**RE: MP09\_0187 MOD 2 – AMENDED PLANS**  
**PROPERTY: NOS. 6-16 ATCHISON STREET, ST LEONARDS**

I am writing with regard to the above Section 75W Application, the Department's email correspondence dated 8 November 2013 and the meeting with the Department on 15 November 2013. The items raised by the Department are addressed below.

GROUND LEVEL RESIDENTIAL ENTRY LOWER

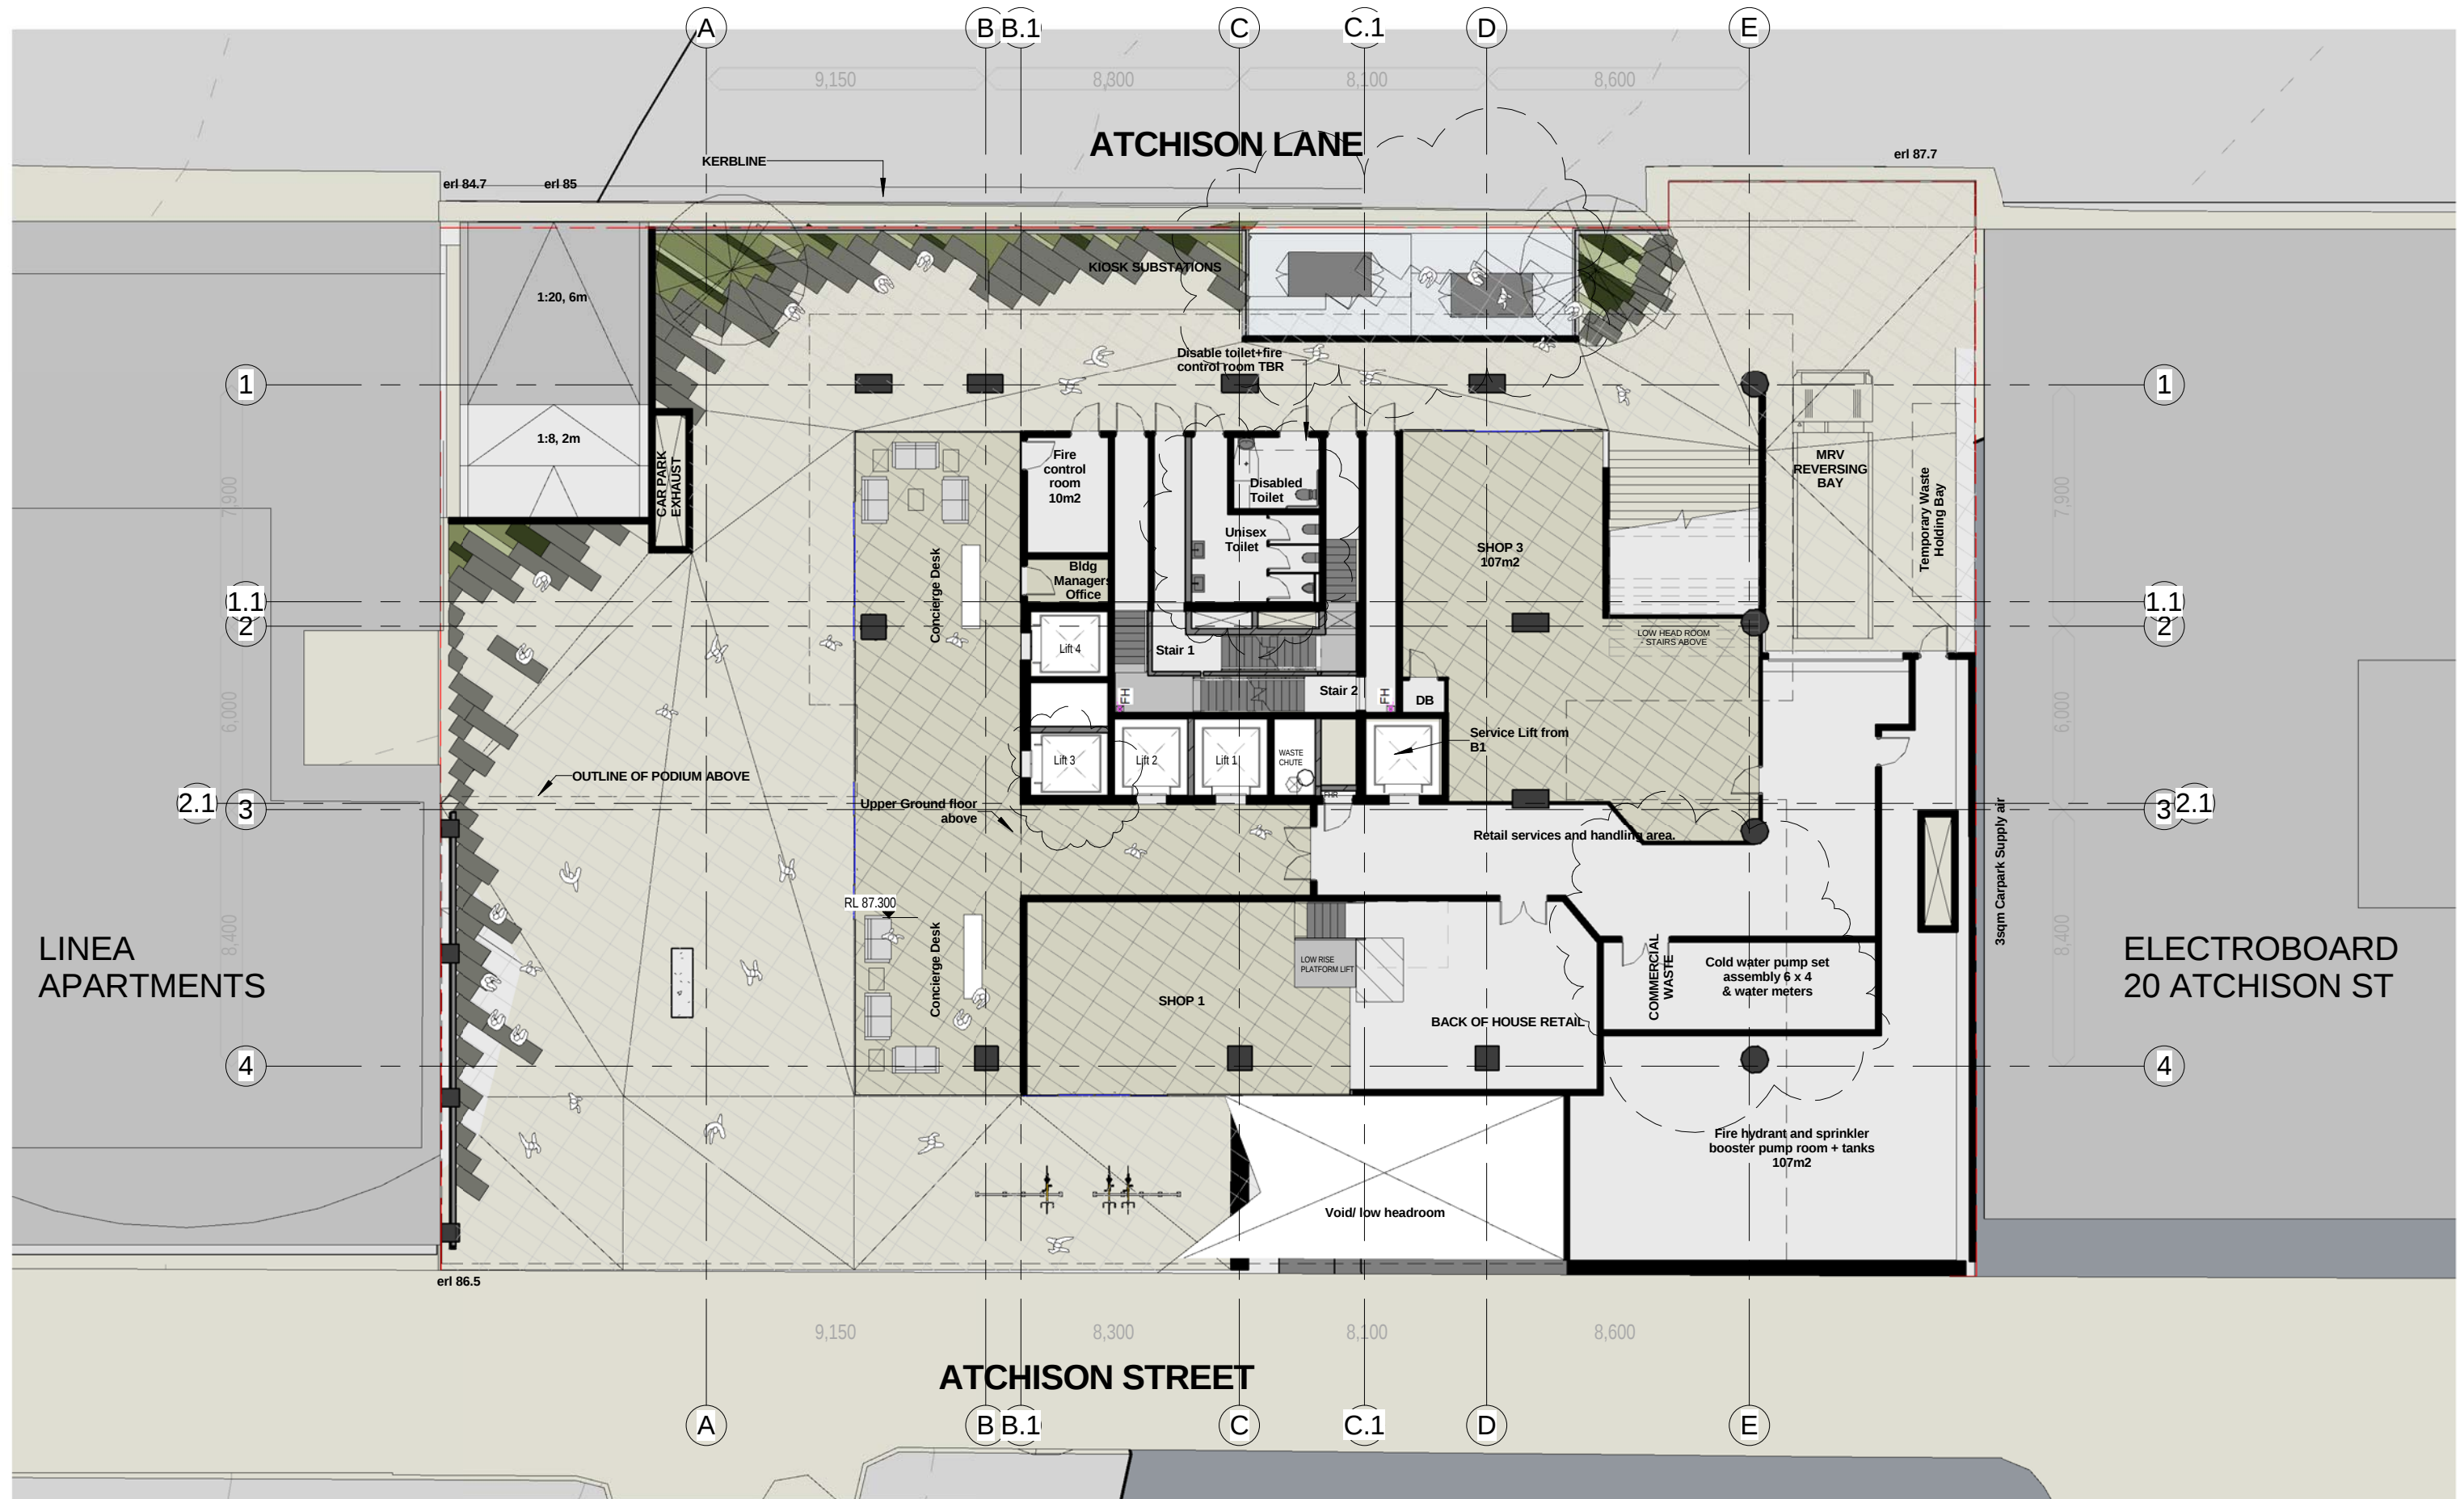
As demonstrated on the revised Ground Level Residential Entry Lower Plan Ref PA-100-02/4, the lobby area now comprises a dedicated lobby area which exhibits a high level of amenity and liveability for the overall development. This area acts as a 'wind lobby' and serves as a general gathering area for the occupants of the building and their guests. Separate lobby areas are also provided for the residential and non-residential components of the building with clearly distinguished lifts and lobbies with secure access.

As shown in **Figure 5** below, the proposed scheme maintains the pedestrian paths of travel throughout the site and provides a direct and pleasant environment and through-site link. The configuration of the rear through-site link offers a high degree of functionality, with the necessary services being located and arranged in an efficient manner which satisfies the relevant requirements. The proposed public domain plane creates areas of retail use and passive recreational areas which complement the use of the site and its functionality.

**Figure 5:** Proposed Ground Level Residential Entry Lower Plan Ref PA\_100-02/4 which demonstrates the majority of the Atchison Lane frontage is landscaped, and the eastern pedestrian entry provides an at grade pedestrian access point which is highly accessible.

BASEMENT LEVEL 1

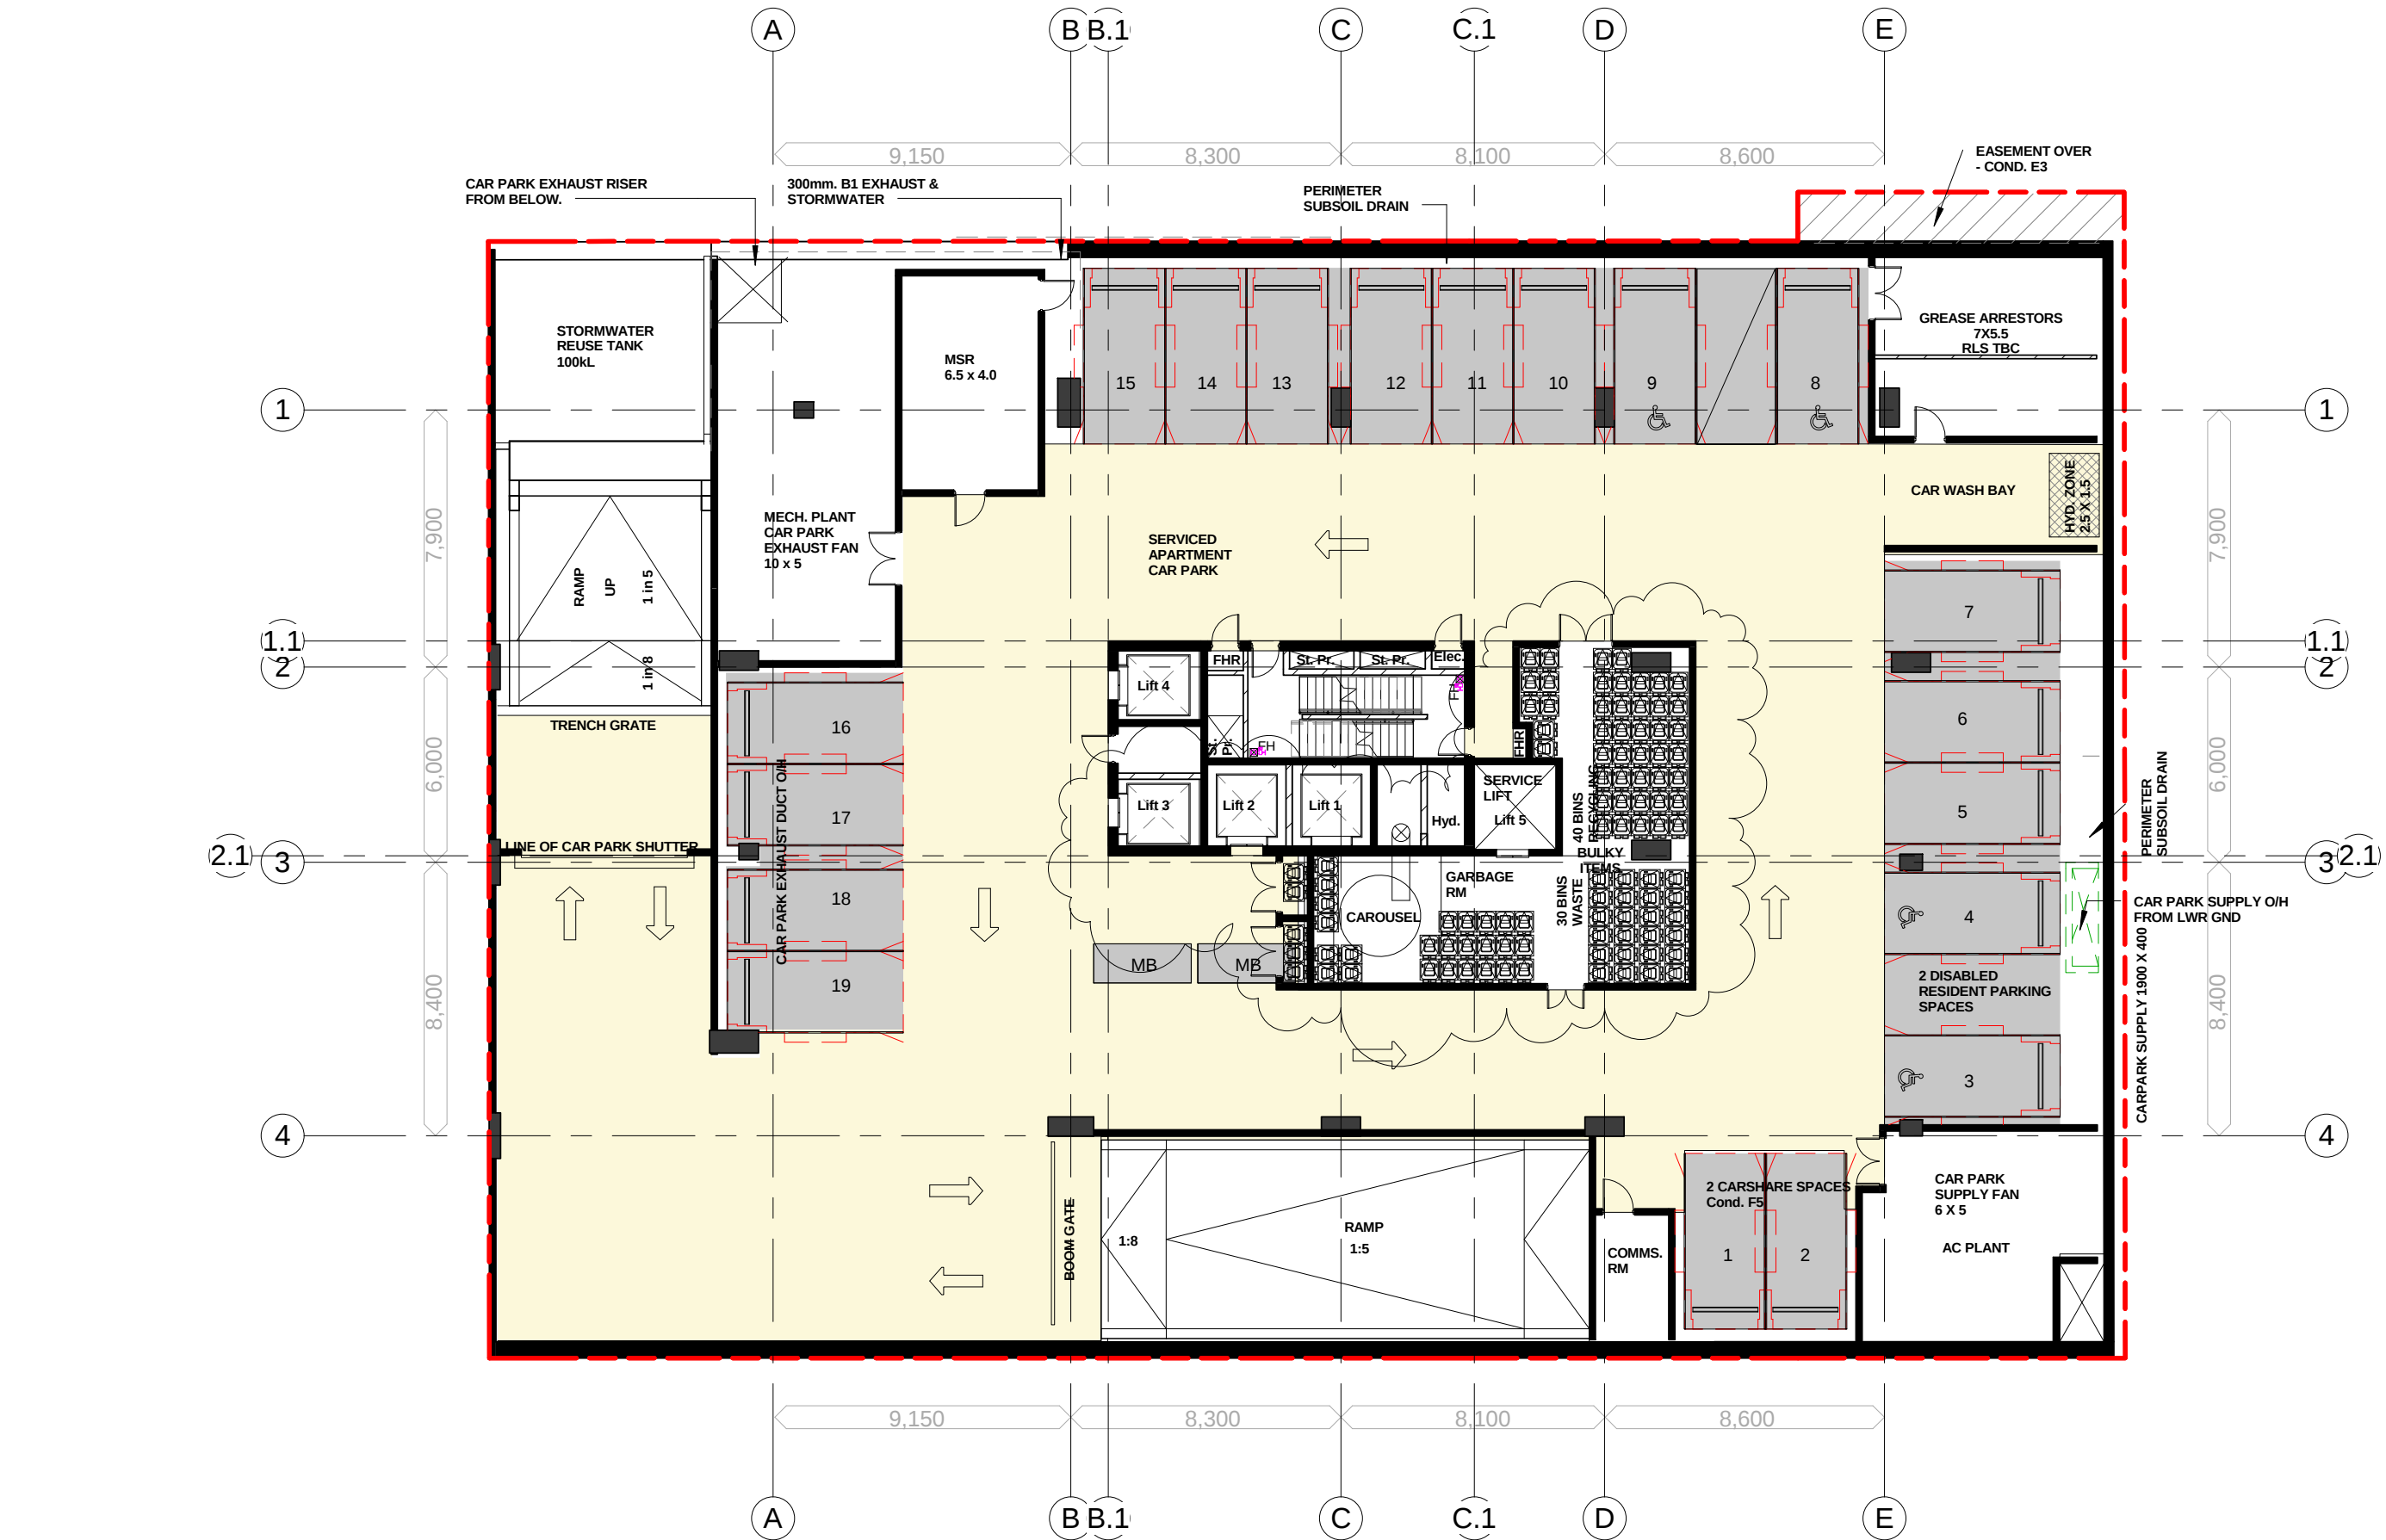
Furthermore, this revised design would require a longer and shallower ramp grade, therefore requiring the circulation area of Basement Level 1 to be revised. As demonstrated in **Figures 1 and 2** above, significant circulation space would also be required for the MRV to manoeuvre within the site to successfully exit by the ramp, as well as additional excavation to satisfy the clearance heights.

It is therefore proposed to retain the design of the basement as per the plans recently submitted to the Department, as this provides a functional vehicular arrangement. That is, SRV access to the basement and MRV access via a loading bay on the eastern side of the site. From **Figure 2**, it can be seen that the MRV will not be highly visible from either Atchison Lane or the public domain areas when deliveries are being made or garbage collection occurring. Noting the garbage collection will be done within the ramp and thus not visible from the lane, this solution is considered more desirable.
